REVISED TOPOGRAPHIC MAP 12.7.21
LOT 7, SHOPTAUGH SUBDIVISION NO. 1
EL PASO COUNTY, COLORADO

Please label all structures as existing or proposed. Is the cul-de-sac on the parcel an existing driveway?

Unresolved Review 1 Comment:
- Please show all easements on the property. Per title commitment submitted by applicant there is a utility easement alongside Northfield Road. Please see document for reference.

LOT BOUNDARY

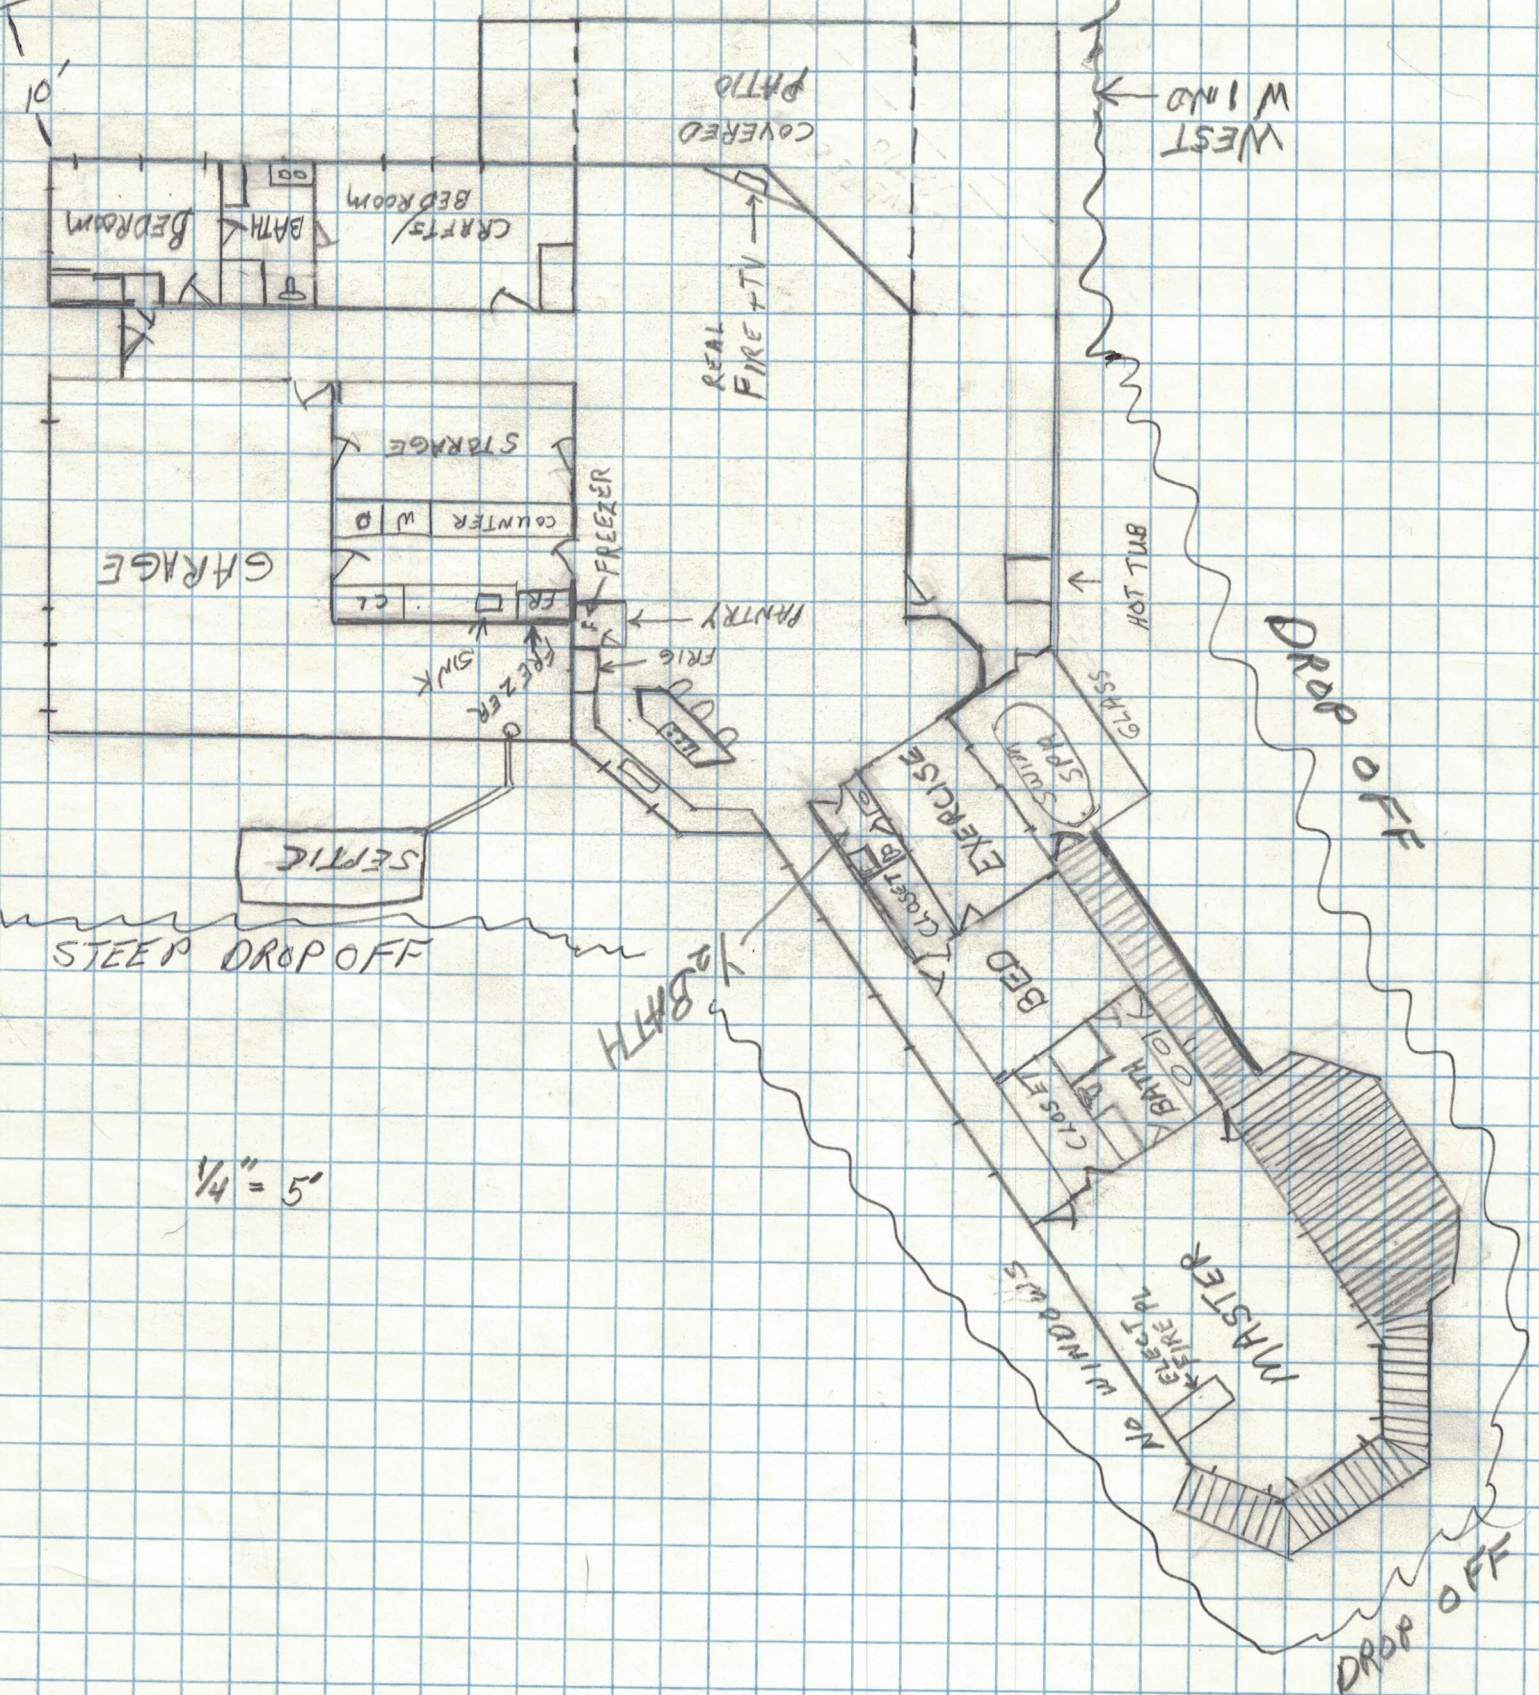
Please add the following:

- Owner name, contact telephone number and email
- Applicant name, contact number and email
- Property address
- Property tax schedule number
- Legal description
- Lot size
- Lot area coverage calculation
- Current zoning of property
- Add the square footage of the proposed home
- Add setback distances from the proposed home and all property lines
- Include any driveways
- Location of all existing and proposed utility lines
